# CITY OF ALBUQUERQUE

**Re: Residence INN & Food Hall**  
**1111 Central Ave. NE**  
**Traffic Circulation Layout**  
Architect's Stamp 06-18-24 (K15-D034D)

Based upon the information provided in your submittal received 06-20-24, the above referenced plan cannot be approved for Building Permit until the following comments are addressed:

RESIDENCE INN & FOOD HALL			
VEHICLE TRACKING EXHIBIT			
DRAWN BY:	LS	DATE:	2/15/2023
CHECKED BY:	JL	BHI PROJECT NO.	20230166
		SHEET NO.	1

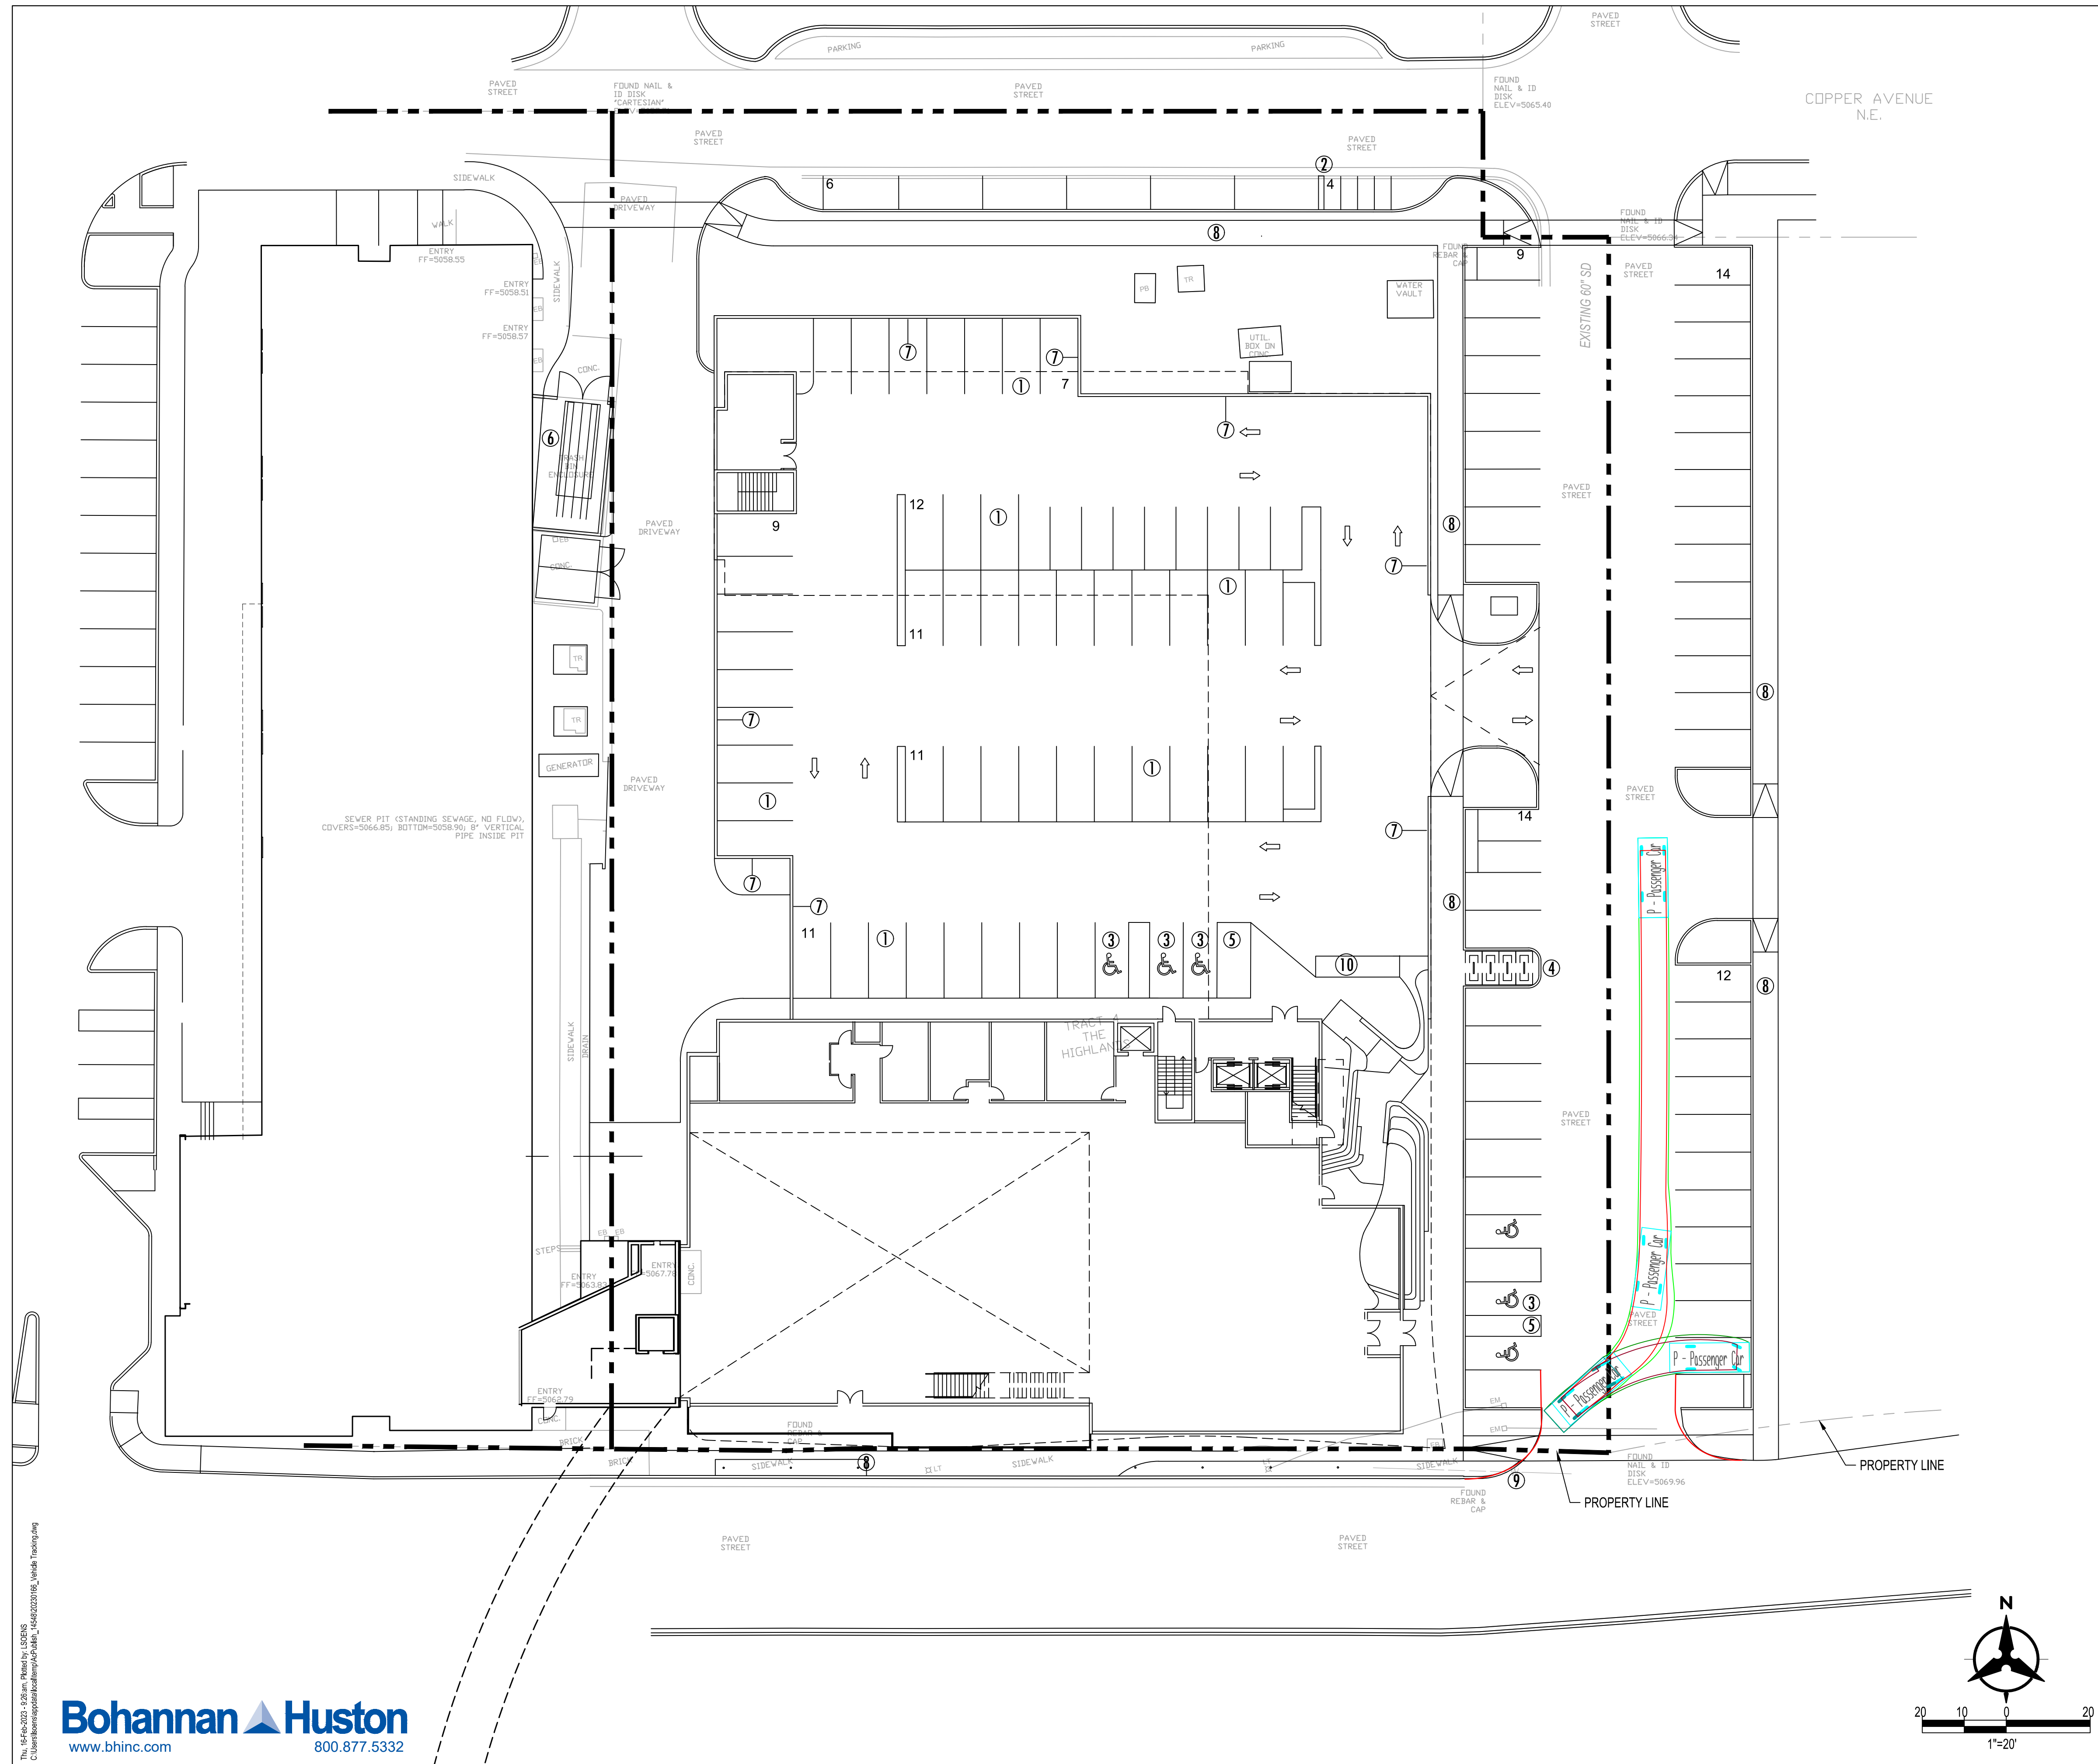
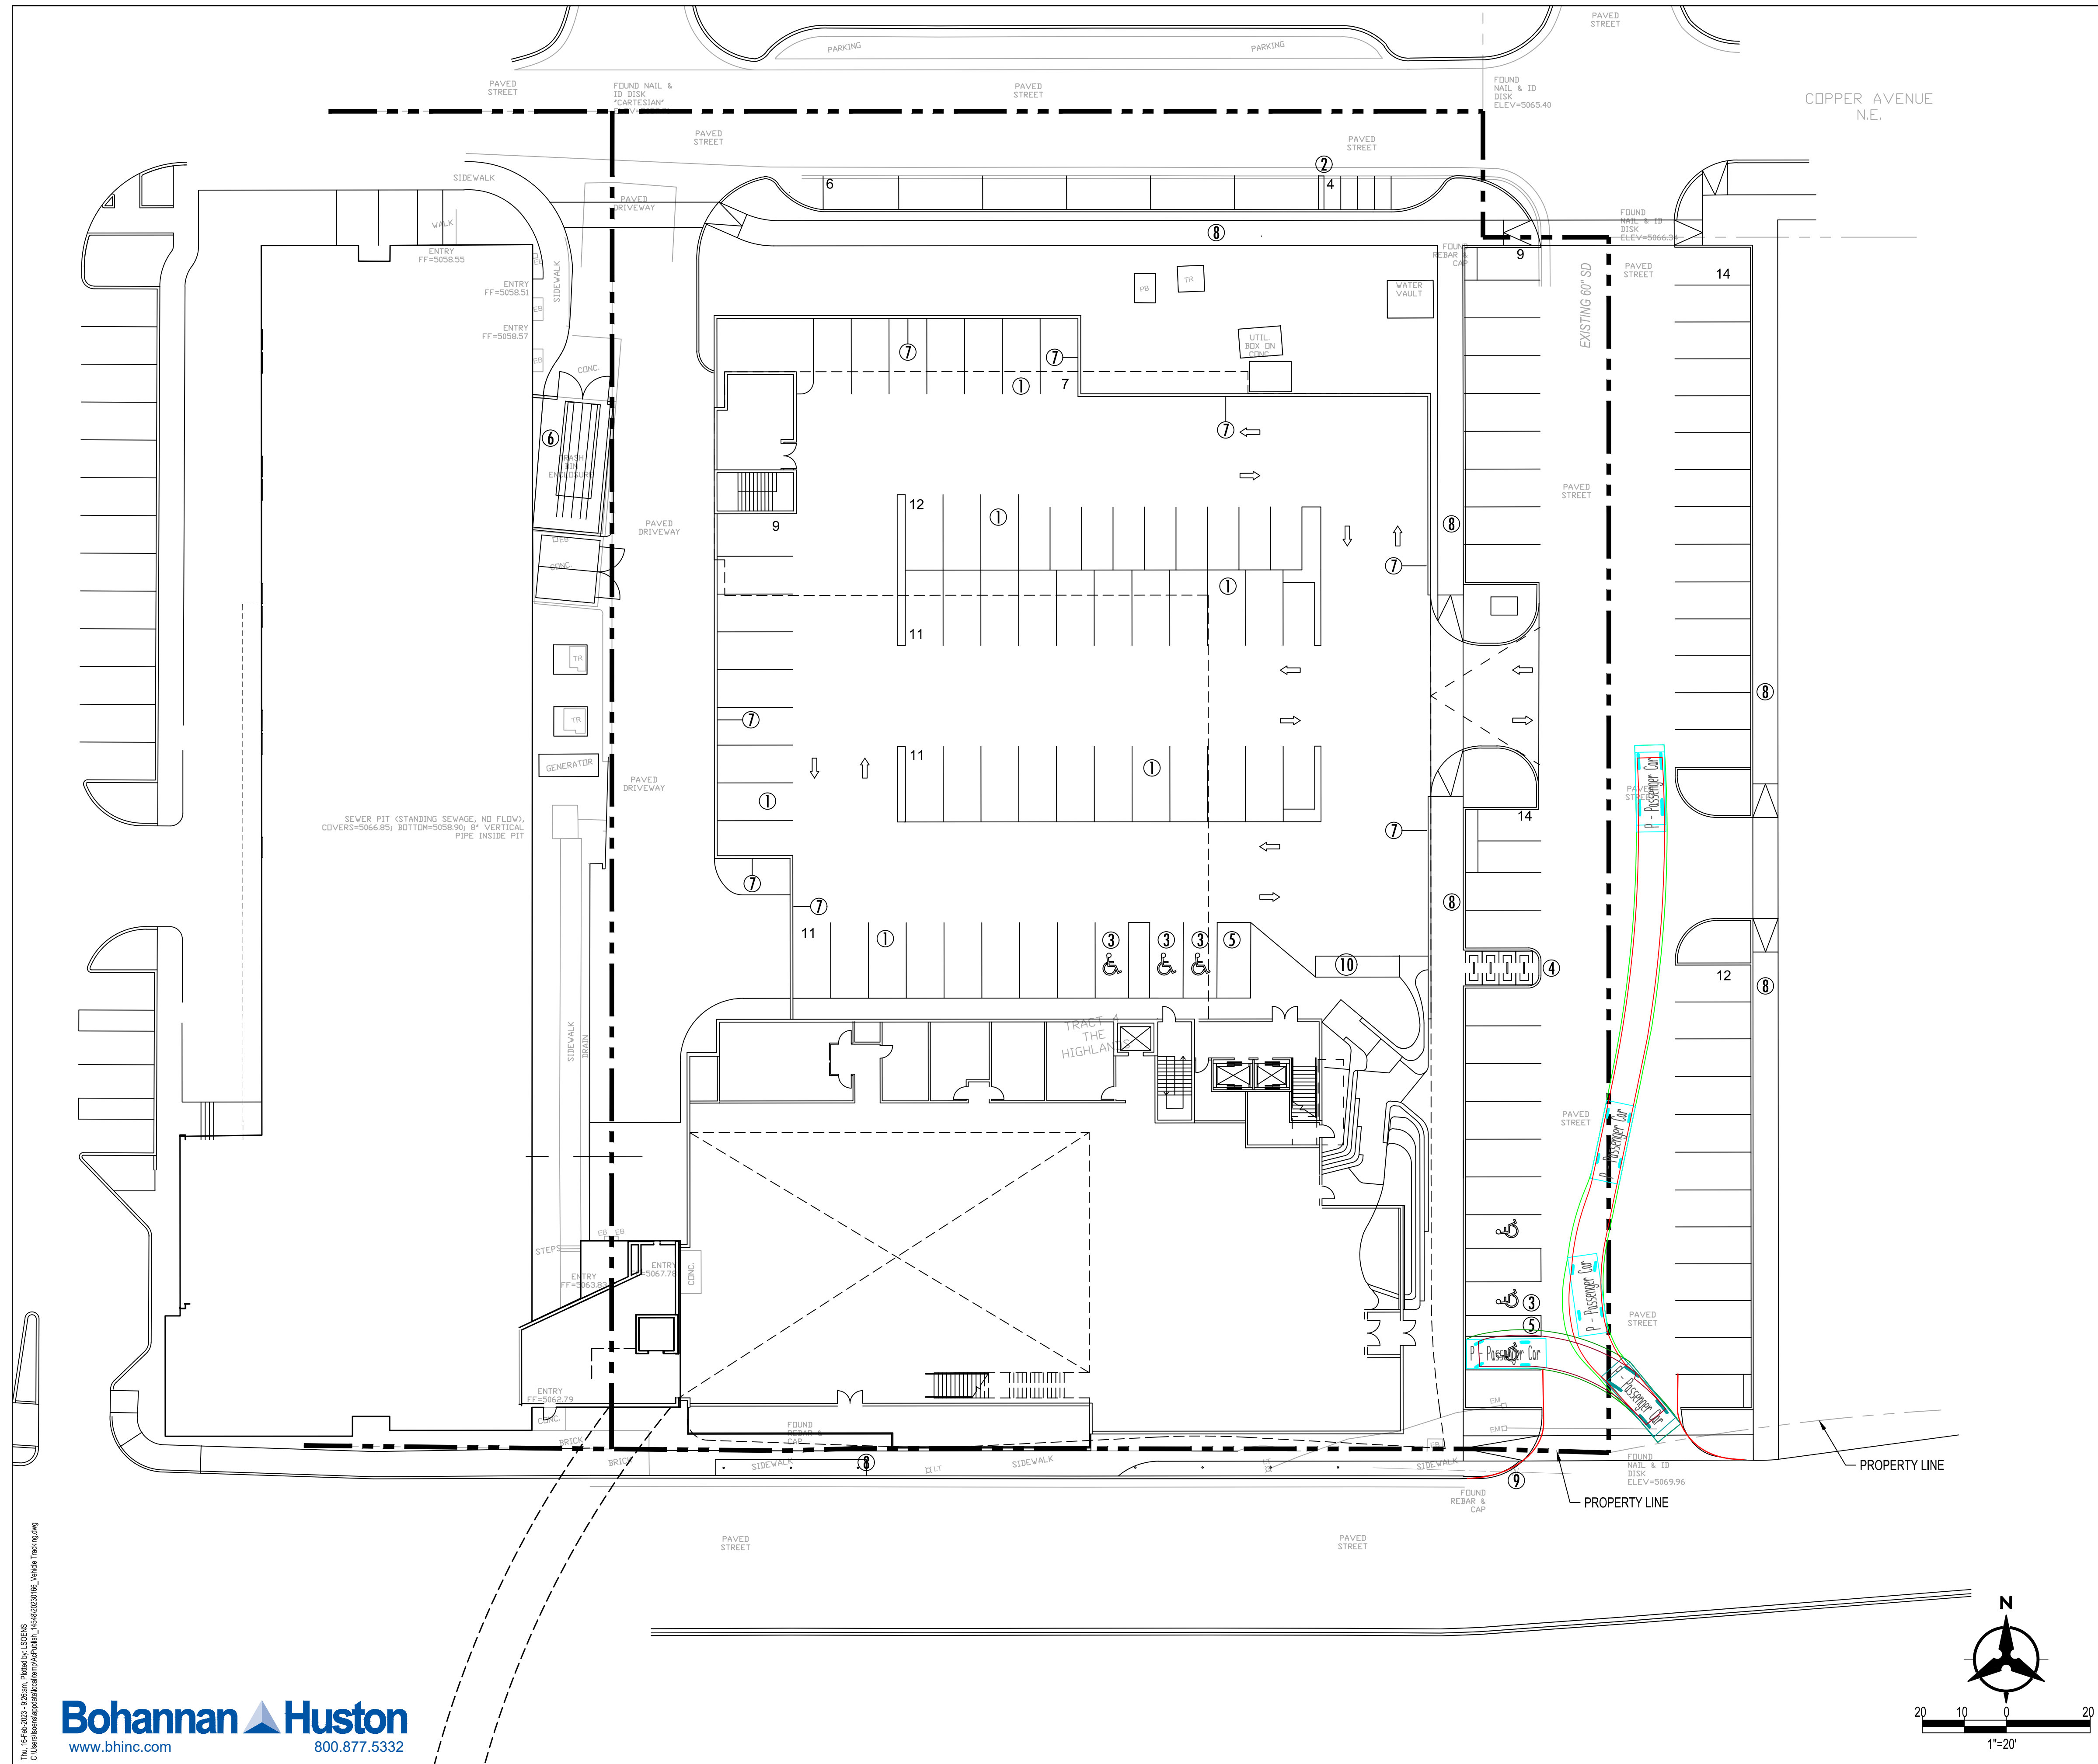
13. List radii for all curves shown; for passenger vehicles. Radius for delivery trucks, fire trucks, etc. is 25 ft. or larger.
14. Provide copy of Fire Marshall approval.

15. Refuse vehicle maneuvering shall be contained on-site. The refuse vehicle shall not back into the public right of way.; provide a copy of refuse approval.
